SP-24-00015 Schmitt

RE: 202405397; SP-24-00015

TO: All Staff
FROM: Public Works Plan Review Team
DATE: December 27, 2024
SUBJECT: SP-24-00015 Schmitt

SCHMITT SHORT PLAT

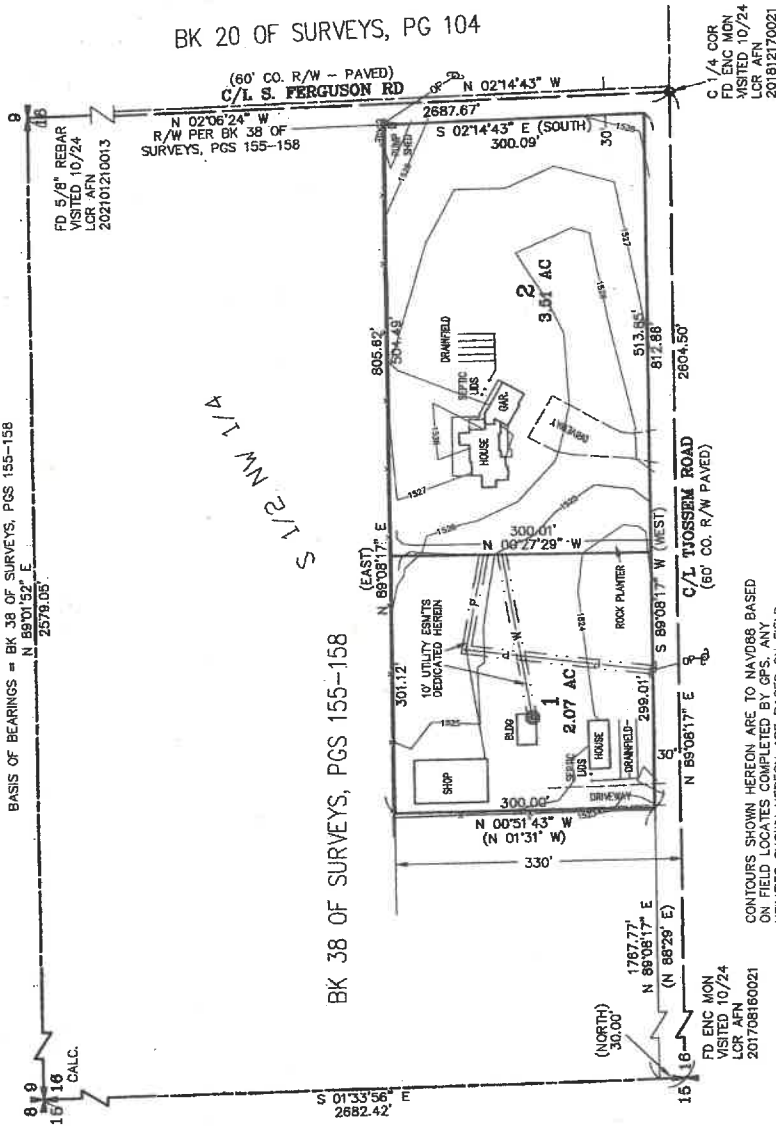
1. Between Lots 1 and 2 a written and approved shared well agreement will need to be submitted between the two lots.

ACCESS	<ol style="list-style-type: none">1. An approved access permit shall be required from the Kittitas County Department of Public Works prior to creating any new driveway access or altering an existing access.2. Maintenance of driveway approaches shall be the responsibility of the owner whose property they serve. The County will not maintain private access.3. Any further subdivision or lots to be served by proposed access may result in further access requirements. See Kittitas County Road Standards.4. In addition to the above-mentioned conditions, all applicable Kittitas County Road Standards apply to this proposal. Access is not guaranteed to any existing or created parcel on this application. <p>OF NOTE: Lot 1 does not have legal access to Tjossem Rd. Under access/address permit # AC-17-00001; requirements were the address be changed to 4871 as the manufactured home was to be removed along with access to Tjossem. For the address to remain 4771 and the access to remain, please submit access/address permit to KCPW. Please ensure that Lot 2 is identified with the address of 4871 Tjossem Rd upon final recording of short plat. (KAH)</p>
